Application number: 2026/90211	
What is the application for?:	Erection of residential development for 9 dwellings with associated works (withi
Address of the site or building:	West House, Oxford Road, Gomersal, Cleckheaton, BD19 4AU
Postcode:	BD7 1NH

Type of comment: An objection	
Do you wish your comments to be published on the website anonymously?	Yes

Proposed Site Plan - Overall 1 : 500

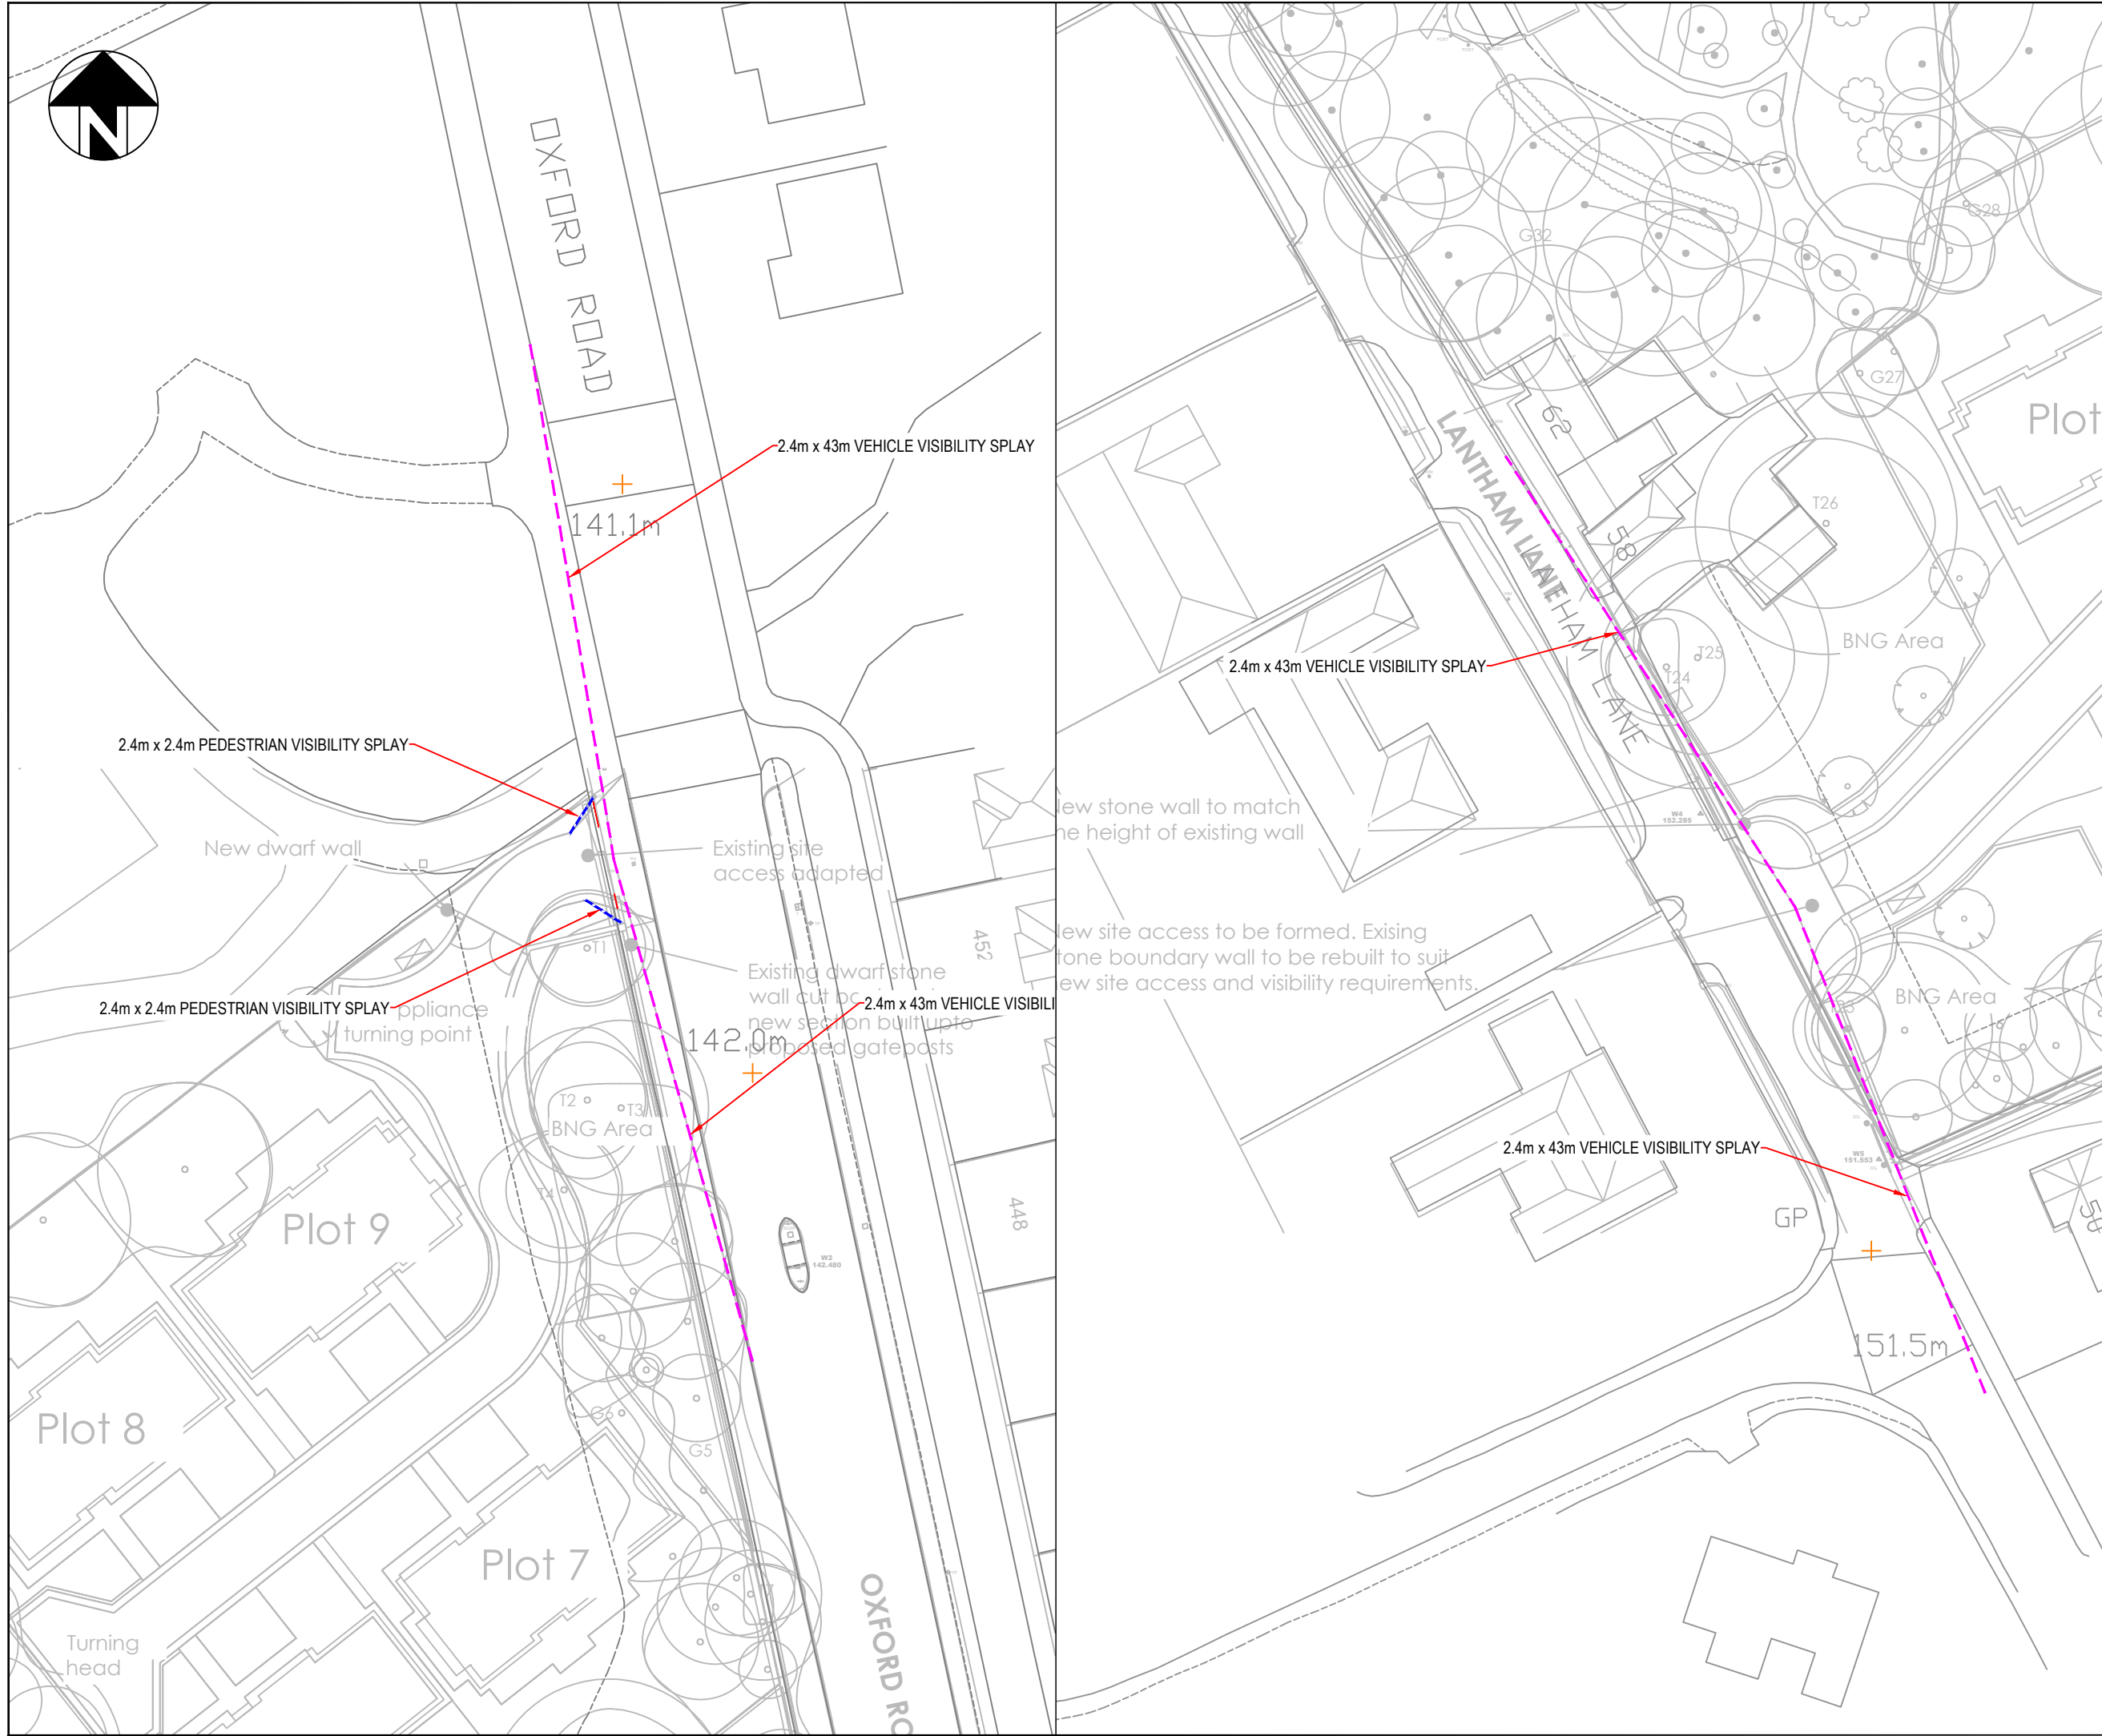
My objection relates specifically to the proposed access from Latham Lane and the resulting impact on highway safety and the character of the area.

The proposed development of nine dwellings, with access onto Latham Lane, would inevitably lead to a significant increase in vehicle movements, including daily residential traffic, visitor vehicles, delivery vans and service vehicles. During the construction phase, there would also be heavy goods vehicles and contractor traffic accessing the site.

Latham Lane is not designed or constructed to accommodate the traffic levels associated with a residential development of this scale. Introducing a primary access point onto such a narrow lane would materially alter its function and character, transforming it from a quiet recreational route into a vehicular access road serving multiple dwellings.

While housing delivery is recognised as important, access arrangements must be appropriate and safe. In this case, the proposed access from Latham Lane does not appear suitable for the scale of development proposed.

For these reasons, I respectfully request that the application be refused, or that alternative access arrangements be required which do not rely on Latham Lane.

Appendix B
Proposed Visibility Splays

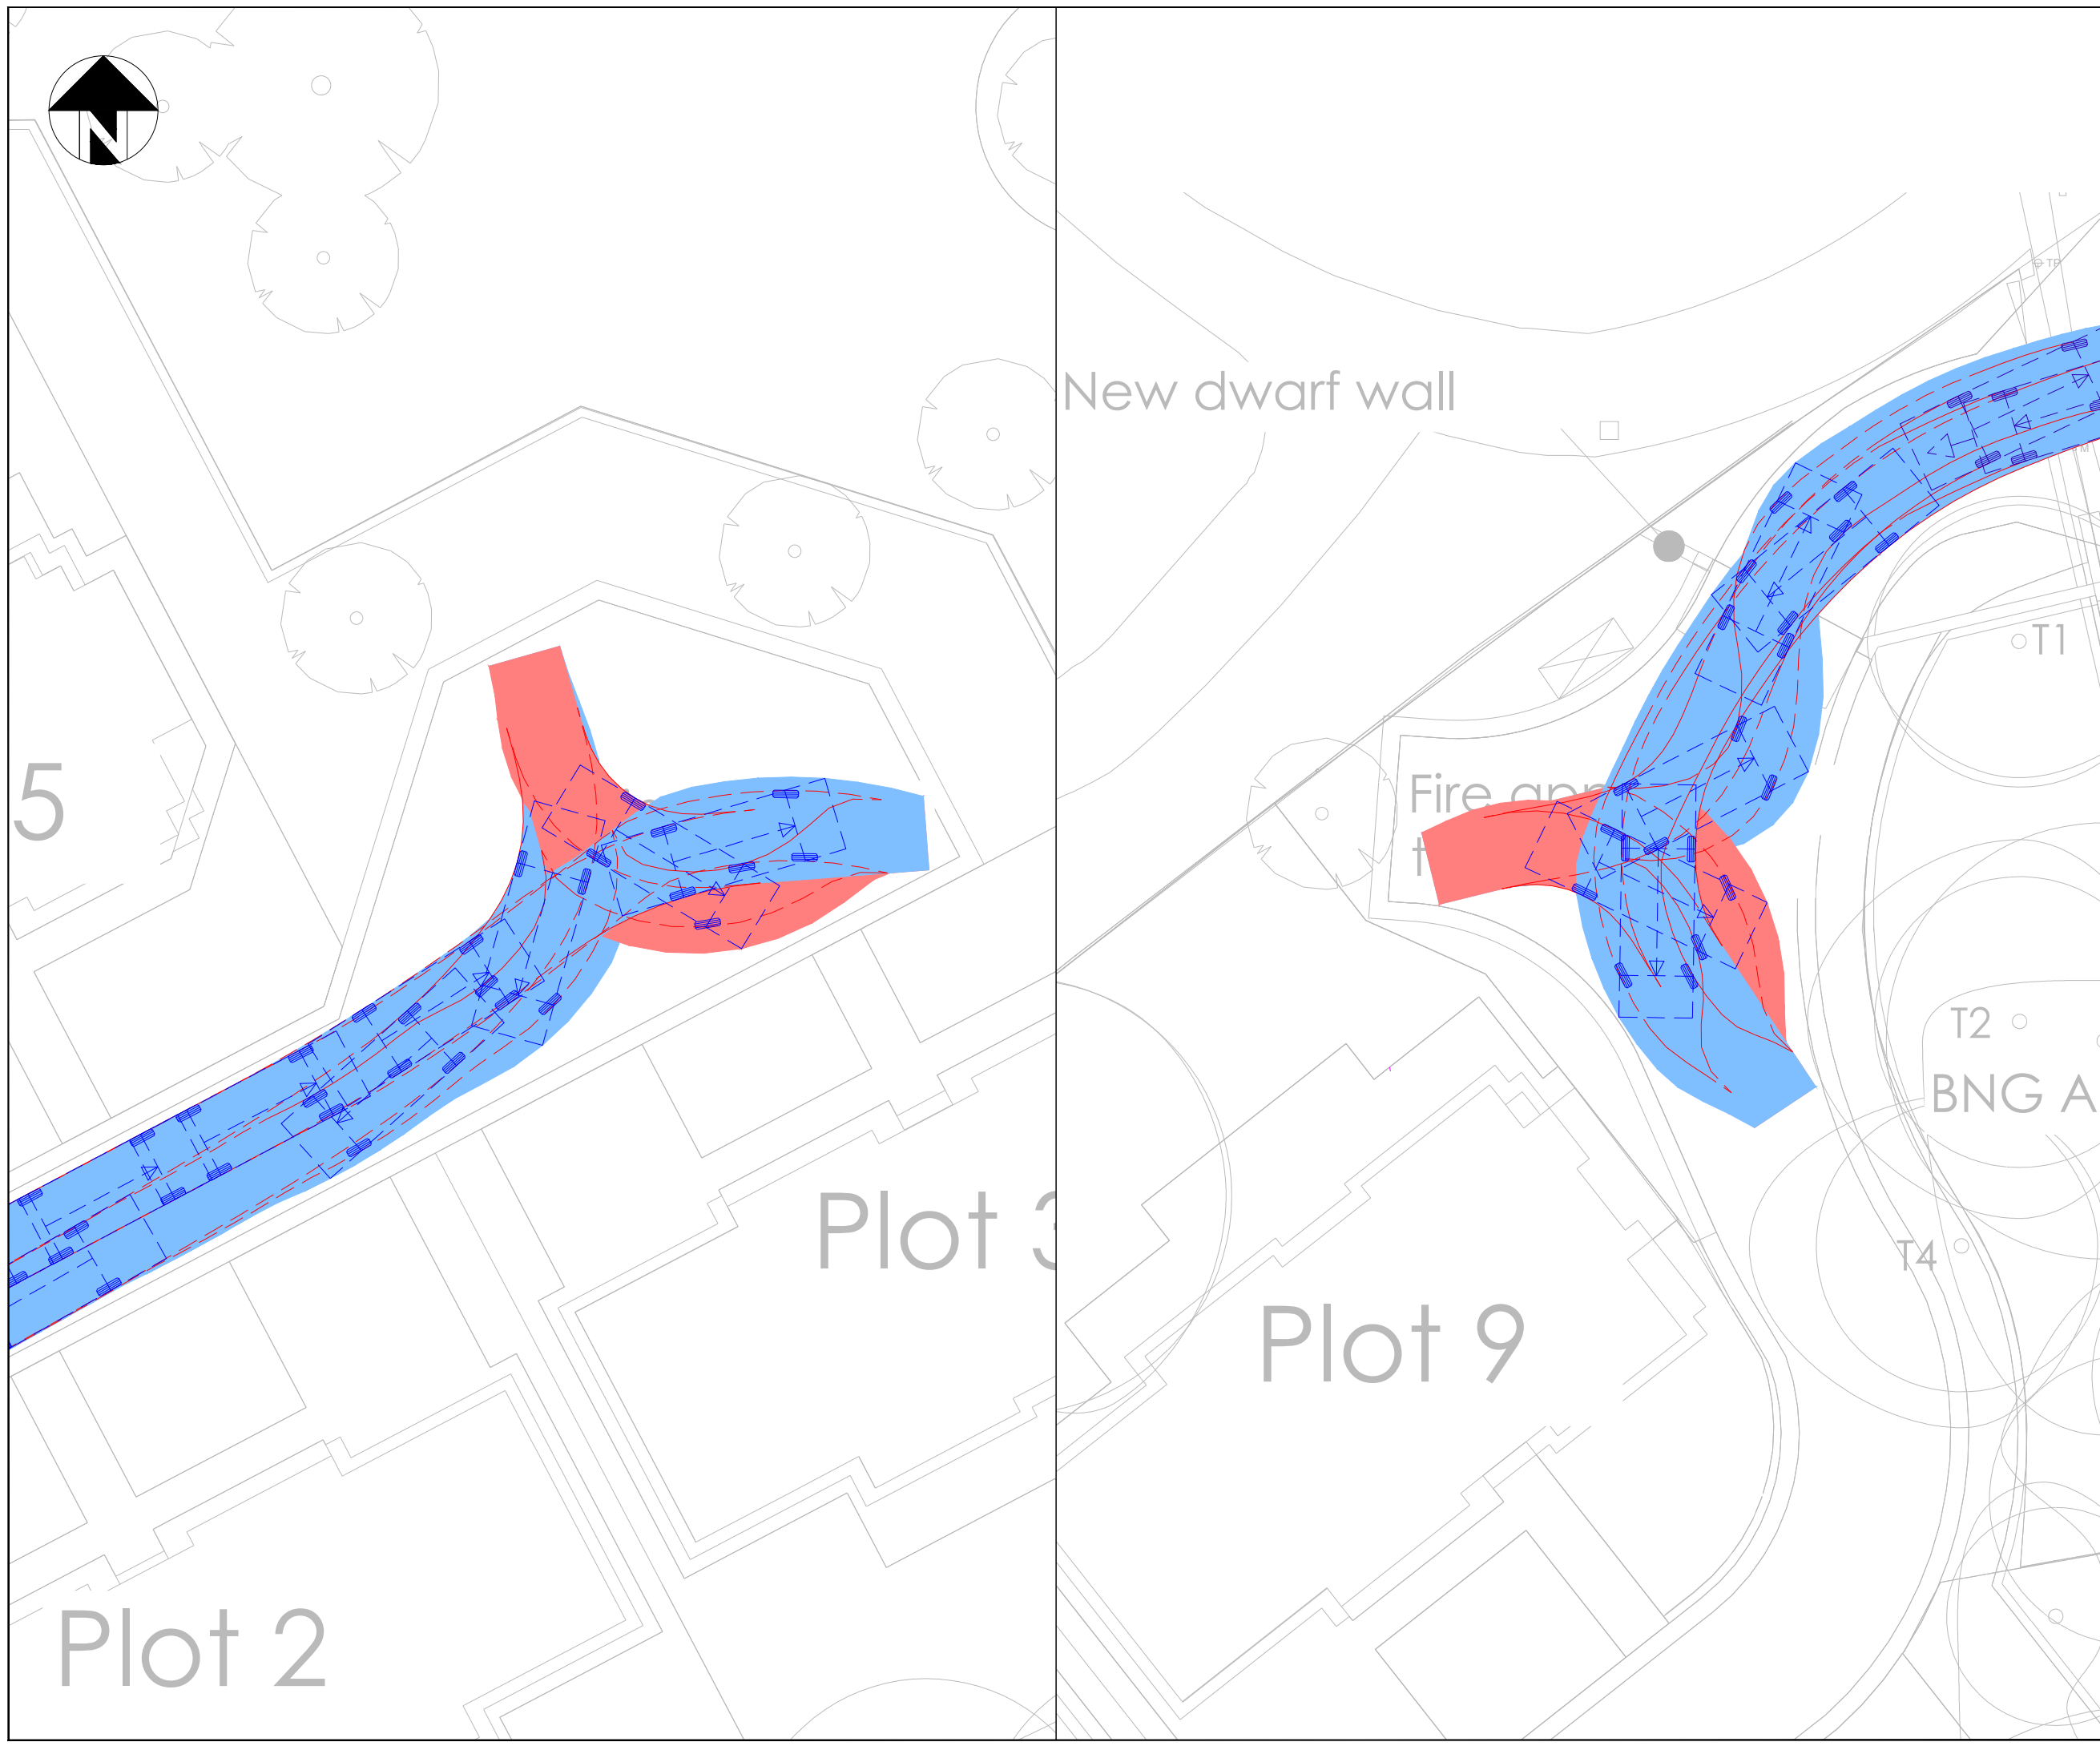
Latham Lane is a narrow, single-track lane with no pavement provision. It currently functions as a quiet, semi-rural dead-end road and is regularly used by walkers, runners, dog walkers and cyclists, in addition to limited vehicular traffic. The absence of footpaths means that pedestrians and vehicles must share the same carriageway space.

Conflict between vehicles passing in opposite directions

Increased risk at points where visibility is restricted
